## RECOMMENDATION FOR PLANNING AND DEVELOPMENT COMMITTEE

**APPLICATION REF:** 3/2026/0135

REGULARISATION OF USE OF LAND FOR OPEN AIR STORAGE OF VEHICLES (WITHIN CLASS B8), PROVISION OF WELFARE UNIT AND JET WASH AT FORMER HOUSEHOLD WASTE RECYCLING CENTRE OFF WHALLEY ROAD, LANGHO BB6 8AB

A3.3

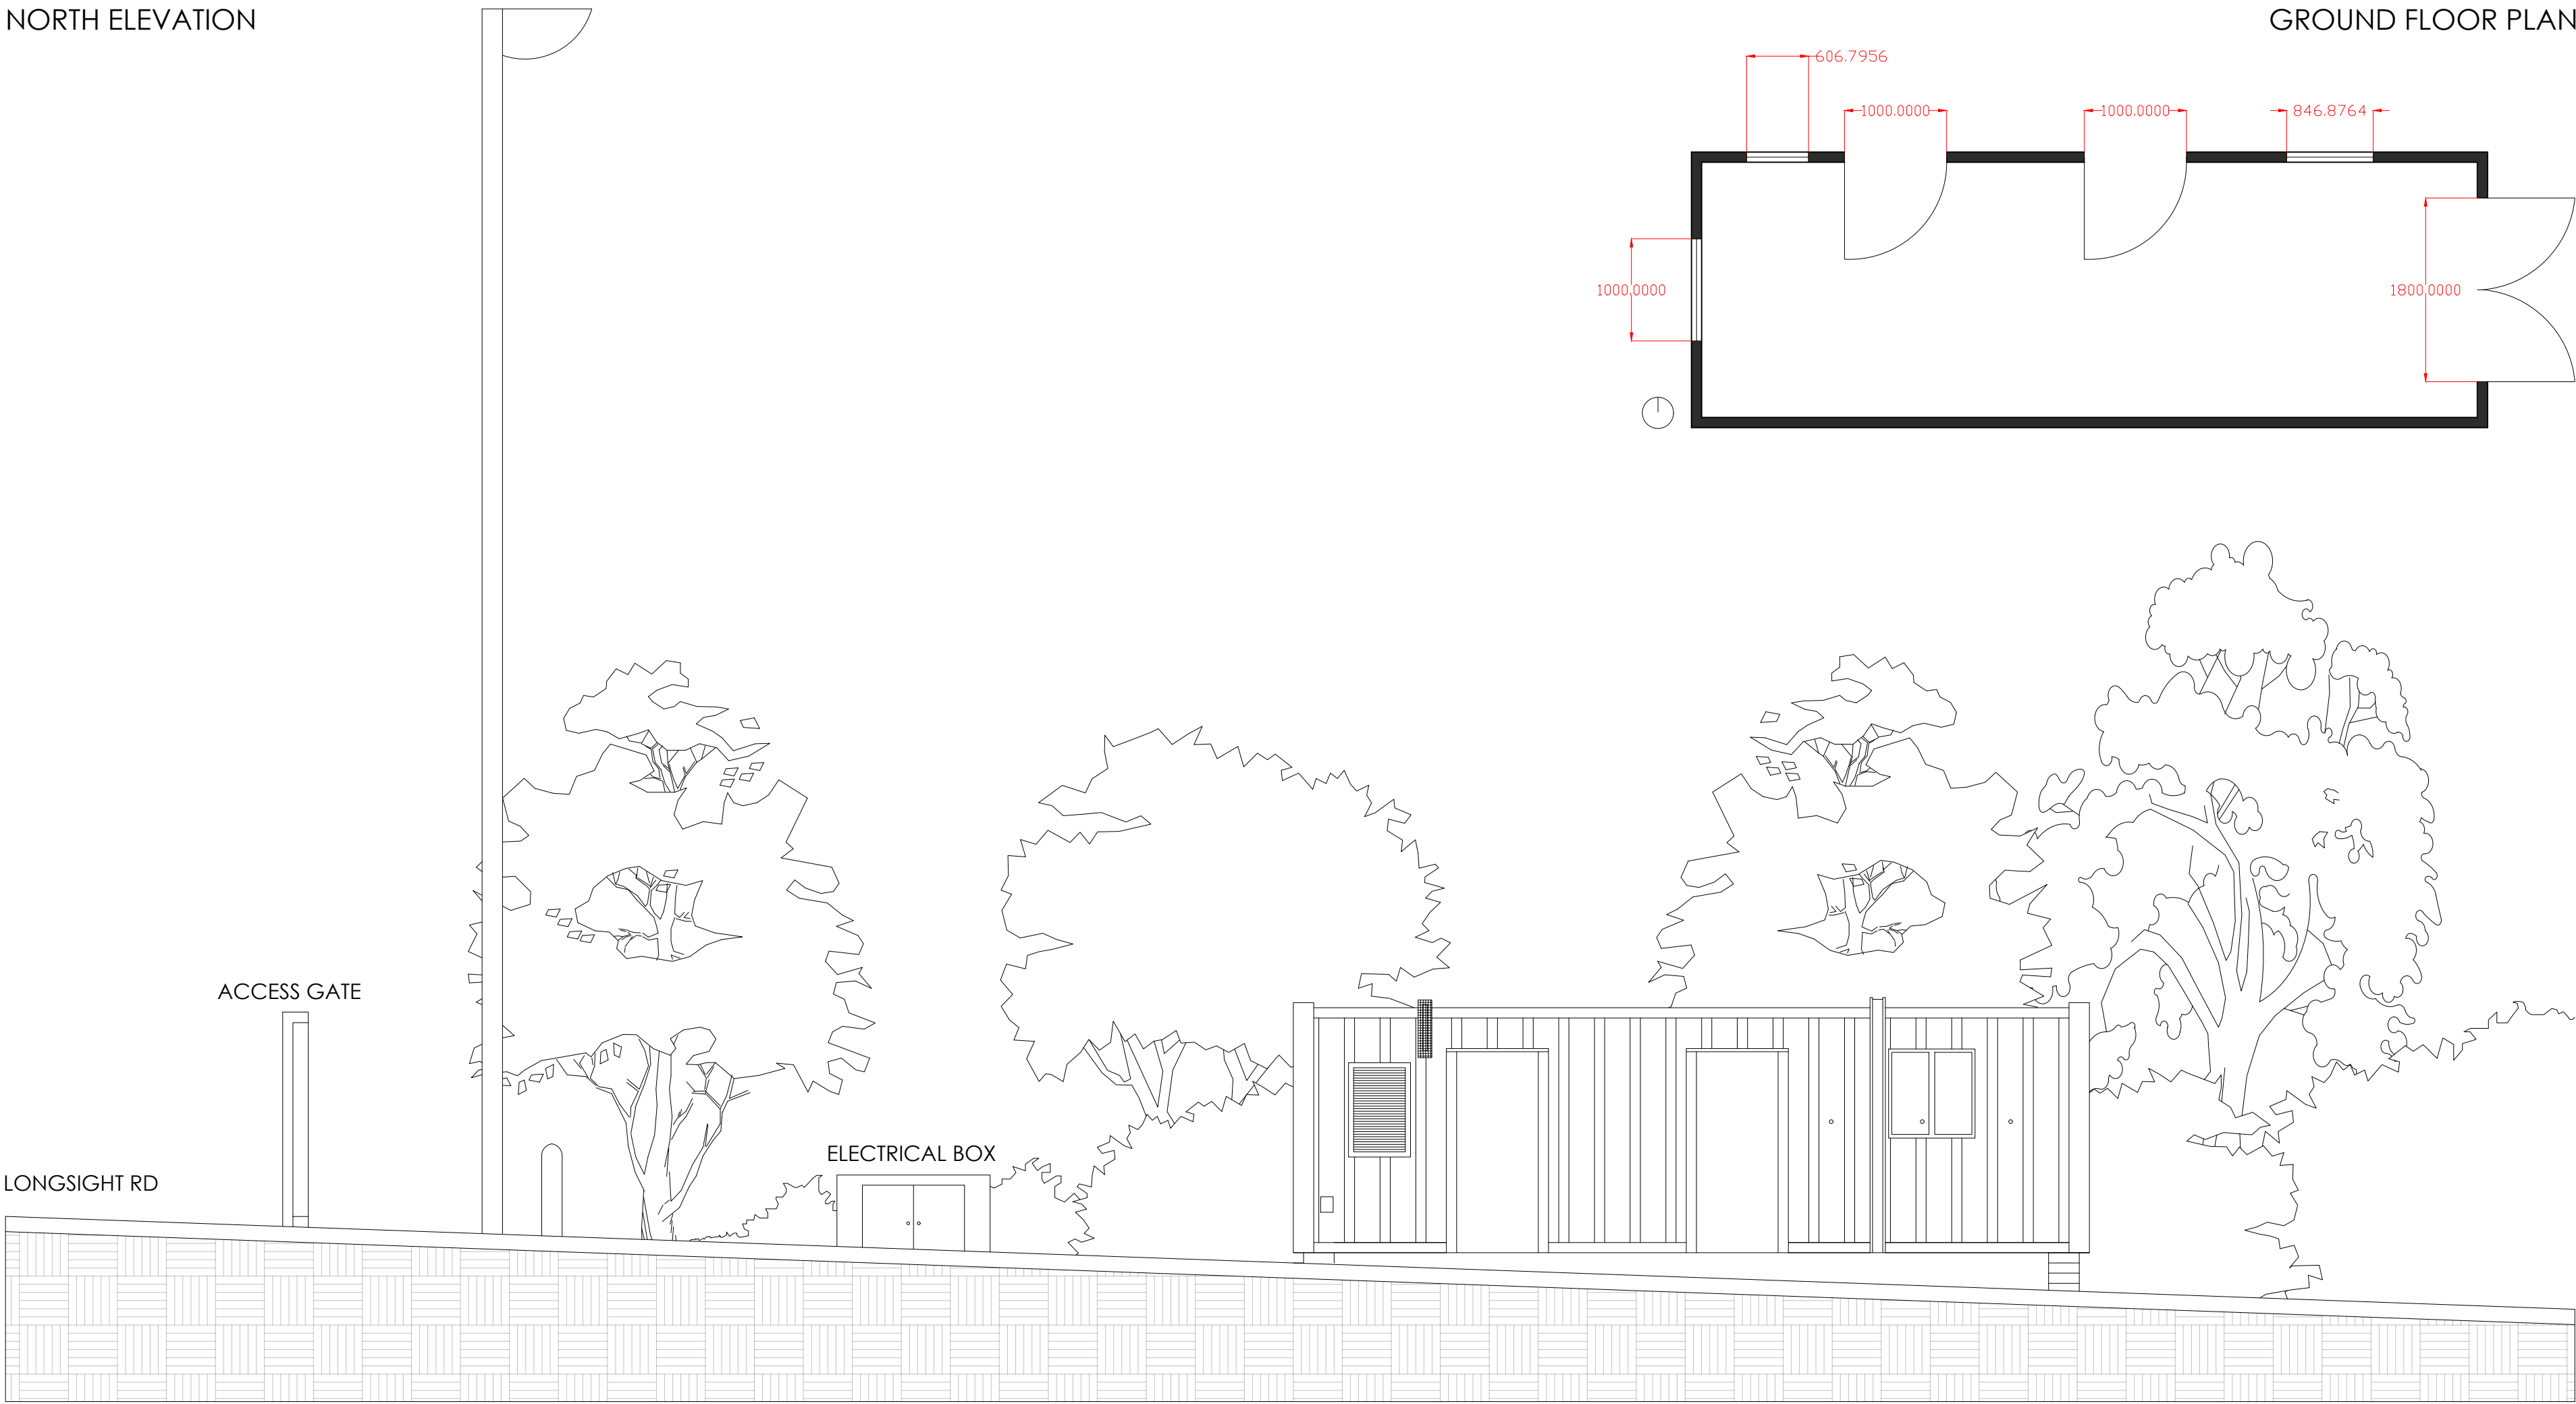
- 5.2.12 Concerns have also been expressed regarding the siting of the proposed welfare container in proximity to residential properties. The structure would be located approximately 8m from the rear boundaries of Nos. 14-17 Petre Wood Close on land at a lower level. It would be modest in scale, with a footprint of approximately 21sqm and a maximum height of 2.8m. Existing boundary treatments are also considered sufficient to provide screening. As such, the structure would not result in any significant adverse amenity impacts by way of overshadowing, loss of outlook, daylight or privacy.

2. The materials to be used on the external surfaces of the development as indicated within the application form and on drawing 'Proposed Floor Plans and Elevations' (dwg no. A3.3) shall be implemented as indicated.

A3.2

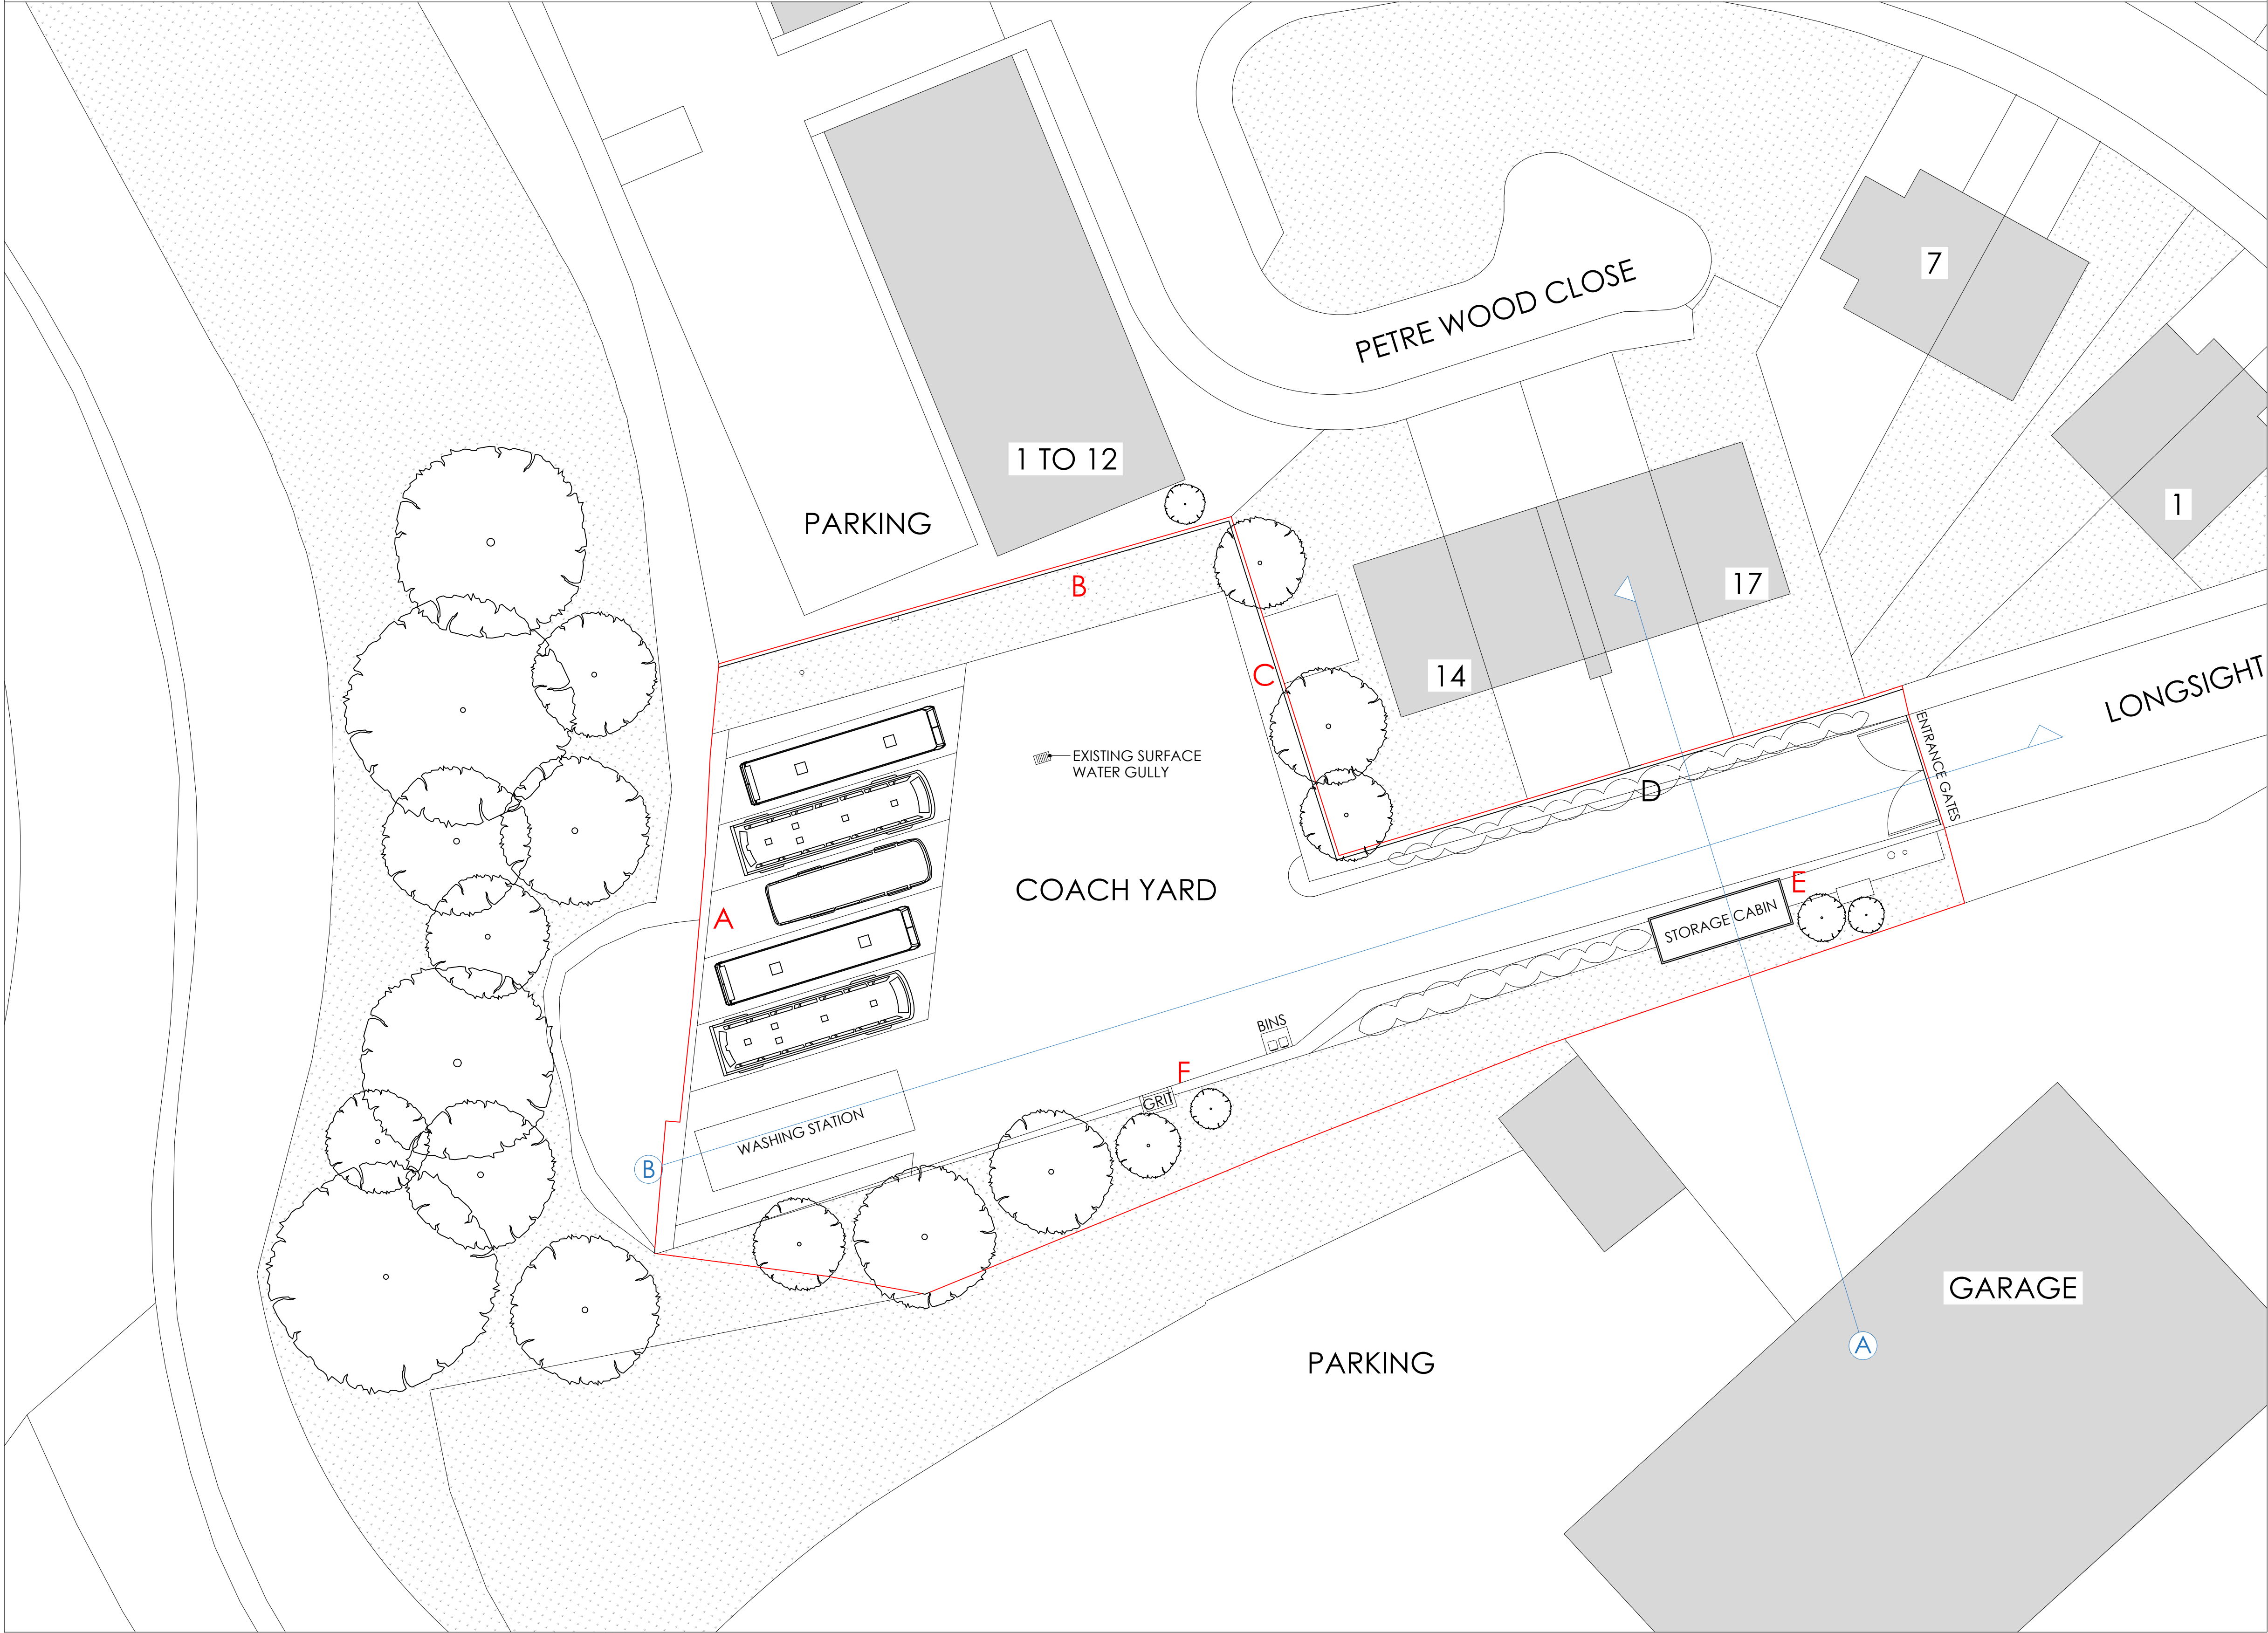
- 5.2.9 Concerns have also been raised regarding noise generated by site operatives. However, such matters fall outside the scope of planning control.
- 5.2.10 Representations also raise concerns regarding debris, overspray, and potential loss of privacy arising from pressure washing activities, including operatives standing on top of vehicles. These impacts can be appropriately mitigated through a condition requiring all pressure washing activities to be confined to the designated 'washing station' area shown on Proposed Site Plan (dwg no. A3.2). This location is the furthest point from residential properties, approximately 28m from No.14 Petre Wood Close and 25m from Nos. 1-12 Petre Wood Close, thereby reducing the potential for noise, overspray and overlooking.

6. Jet washing activities shall be restricted to the area marked as 'washing station' on the 'Proposed Site Plan' (dwg no. A3.2) only.
